Rezoning Transportation Analysis

Petition Number: 2022-134

Date	Description
01-26-23	First Review (PDM)
02-22-23	Second Review (JP)

RZ1.0

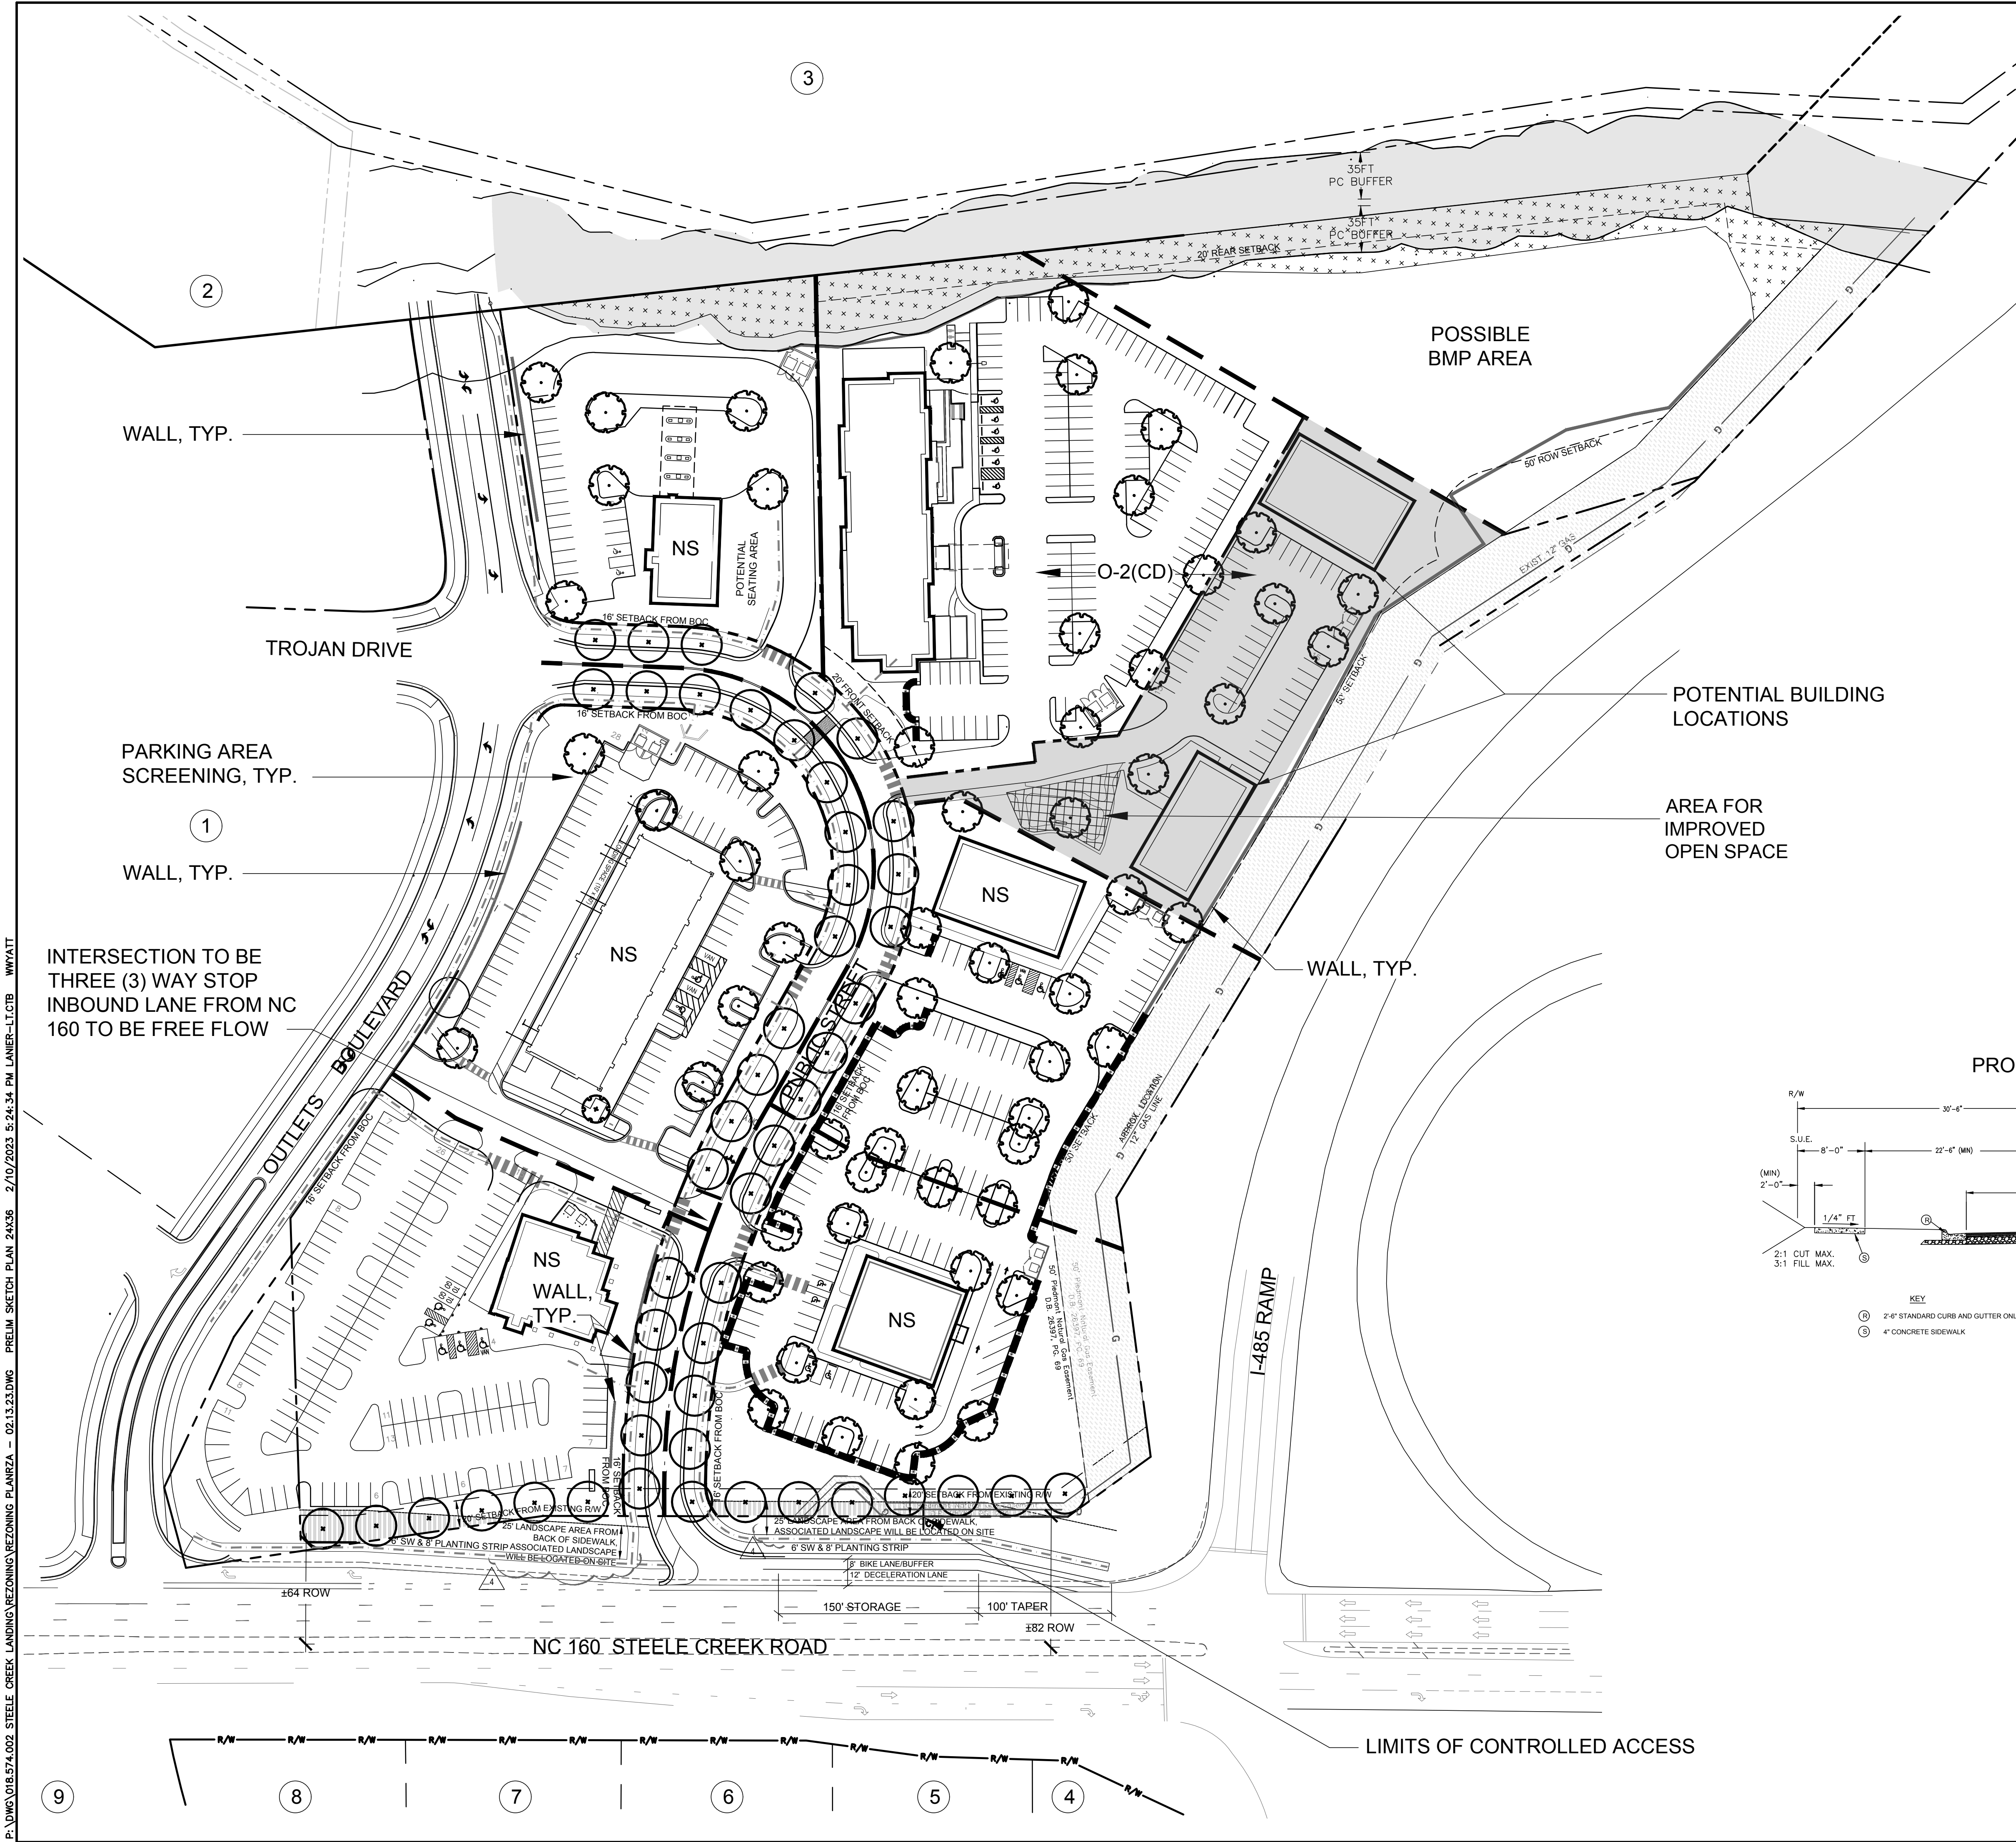
3. Add callout and conditional note for the proposed intersection control to be approved by CDOT during permitting for the below intersection.

Clarifying Comment from 2-22-23: Add conditional note and callout

4. Add a conditional note specifying "A Right-of-Way Encroachment Agreement is required for the installation of any non-standard item(s) (irrigation systems, decorative concrete pavement, brick pavers, etc.) within a proposed/existing City-maintained street right-of-way by a private individual, group, business, or homeowner's/business association. An encroachment agreement must be approved by CDOT prior to construction/installation. Contact CDOT for additional information concerning cost, submittal, and liability insurance coverage requirements."

Clarifying Comment from 2-22-23: Add conditional note

5. Add a conditional note specifying "the Petitioner shall dedicate and convey in fee simple all rights-of-way to the City before the site's first building certificate of occupancy is issued. CDOT requests rights-of-way set at 2' behind back of sidewalk where feasible."

Clarifying Comment from 2-22-23: Add "CDOT requests rights-of-way set at 2' behind back of sidewalk where feasible." at the end of the conditional note
